Consultation Response from KC Highways Development Management		
2025/91127 Oxford Grange, 30 Oxford Road, Dewsbury, WF13 4LL		
Change of use of residential care home to 21 apartments, erection of coach house to host 2 apartments with associated external works (within a conservation area)		
Date Responded: 17/06/26	Responding Officer: M Zenner	Responding Ref: 14-10SW/22

RECOMMENDATION: Amendments and further information required.

SCALE @ A3: 1:250	CHECKED: AT	APPROVED: AT
CAD FILE: 26017-SPA_VIS.dwg	DESIGN-DRAWN: TS	DATE: 26/05/2026
PROJECT No: 26017	DRAWING No: 26017/VIS/001	REV: A

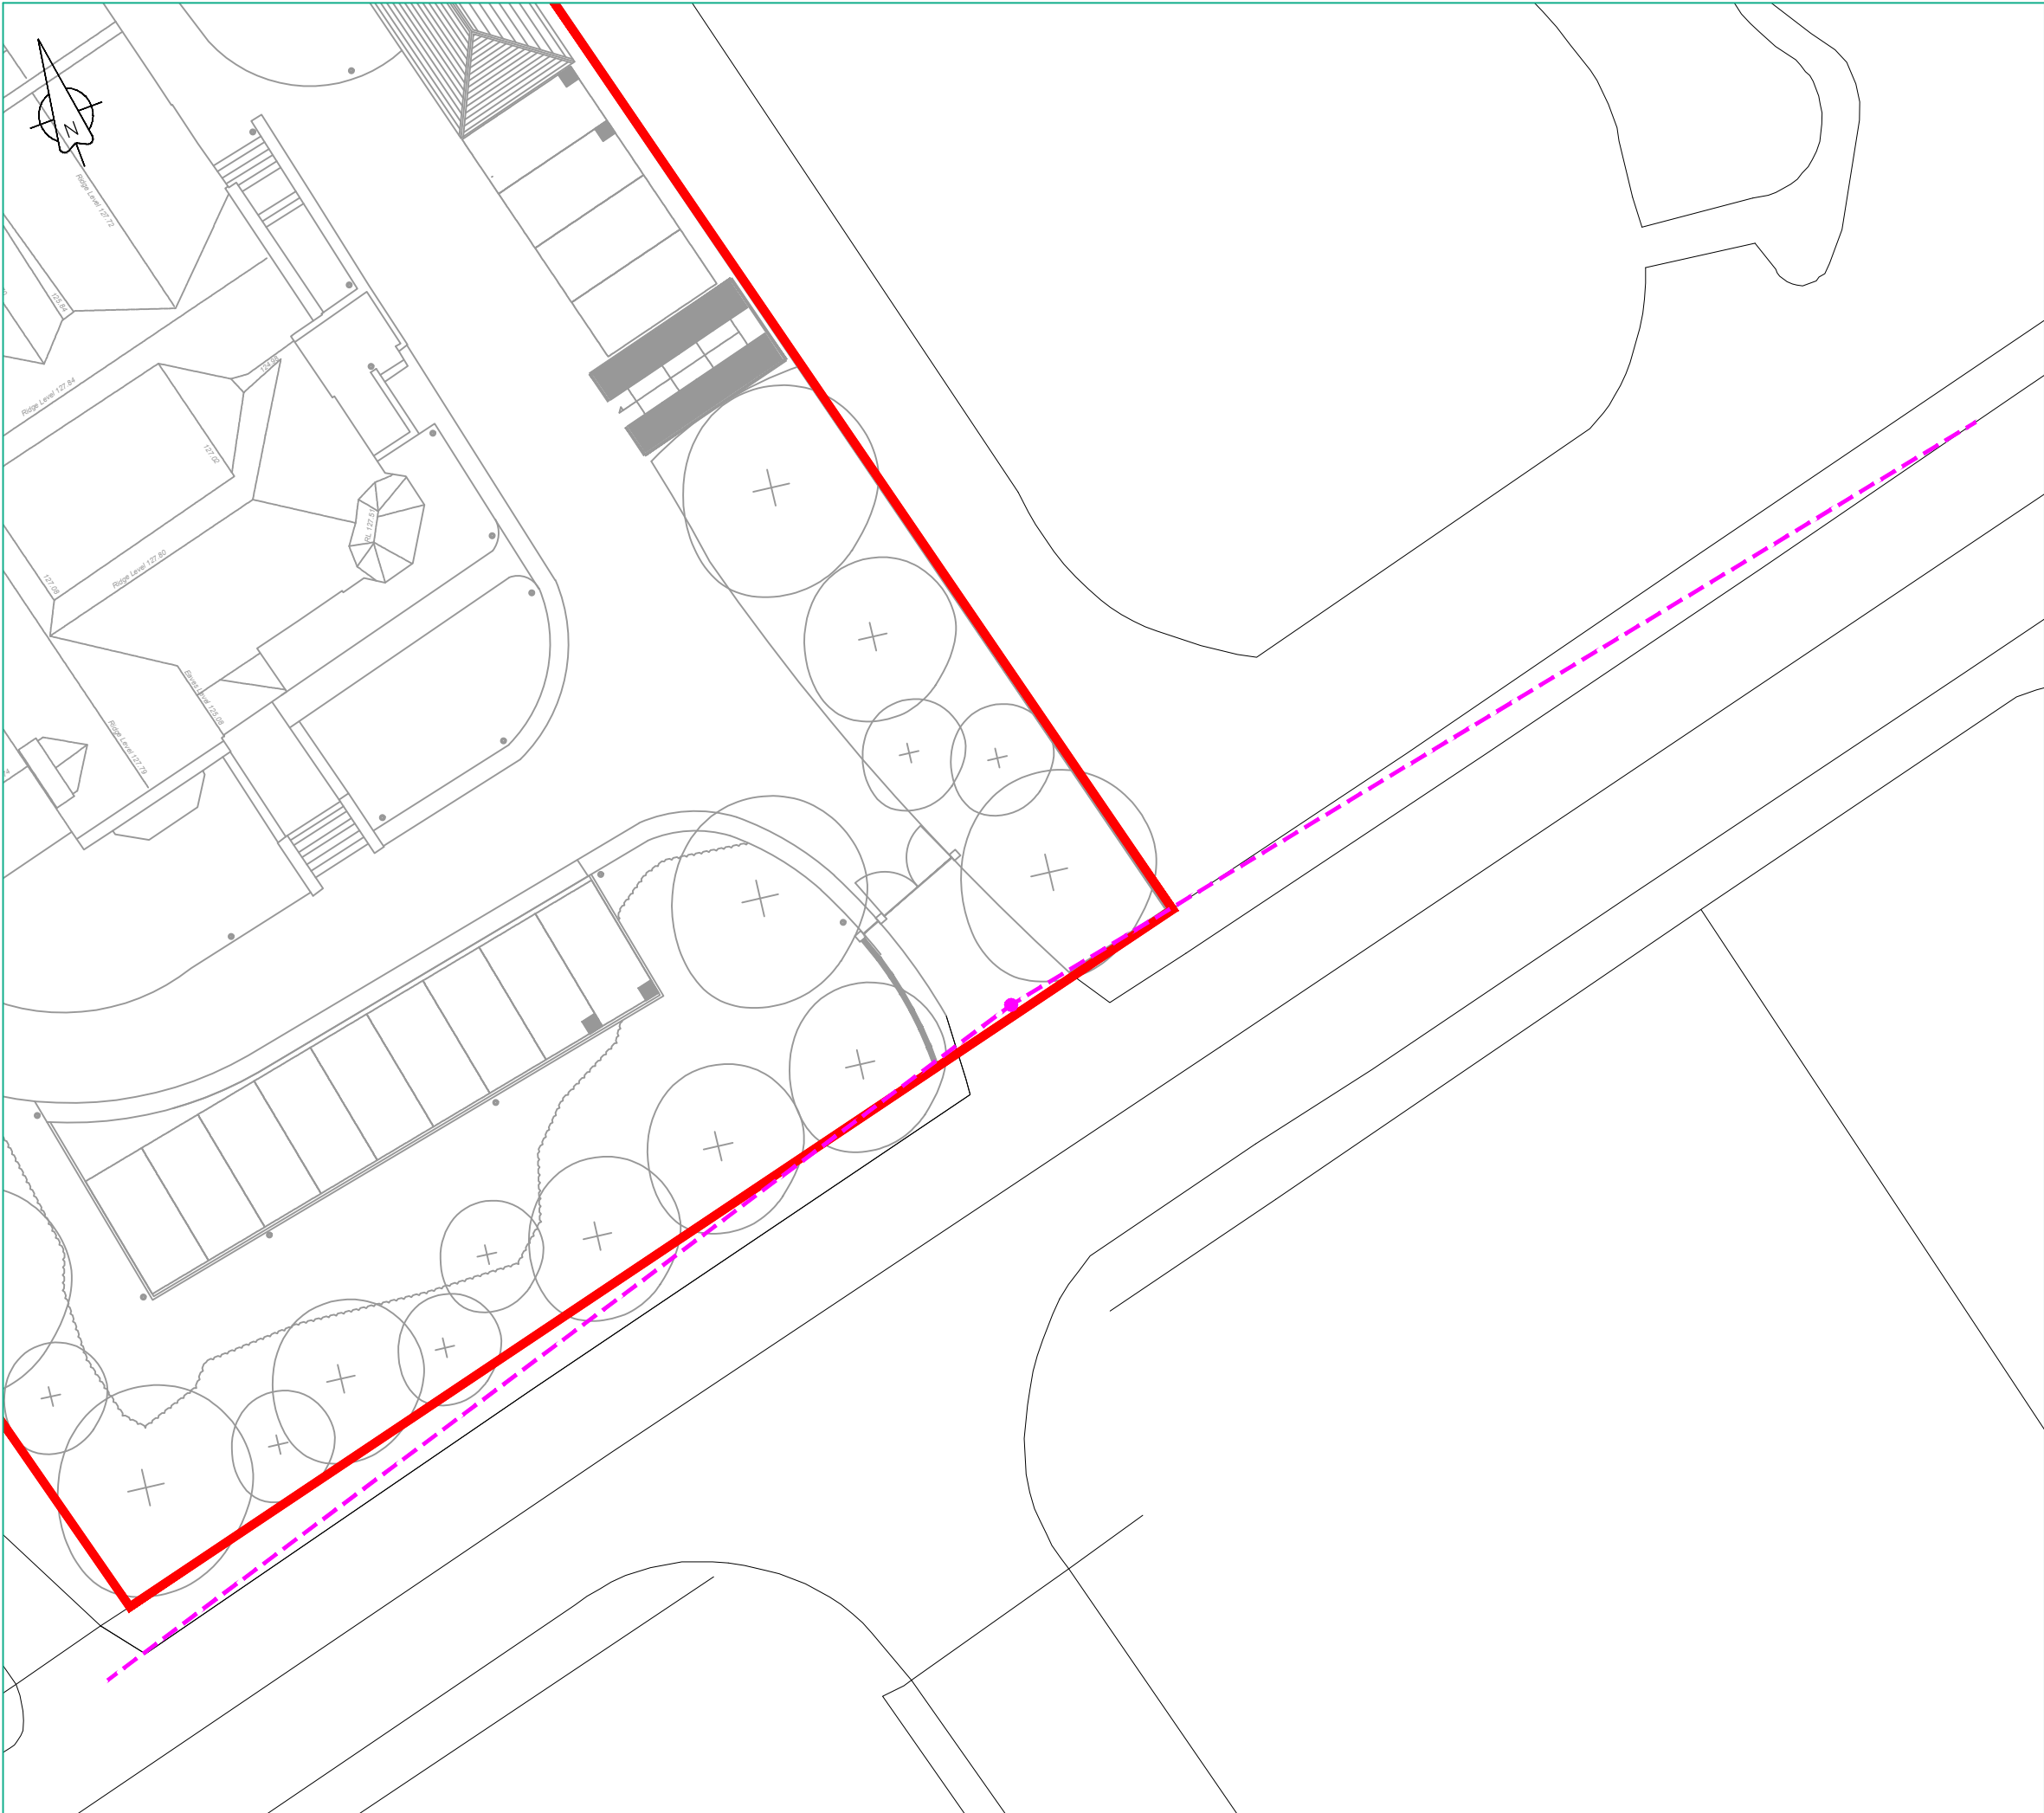
Visibility splays have been provided on the block plan but are drawn incorrectly to the centre line on Oxford Road rather than the nearside kerbline and should be amended.
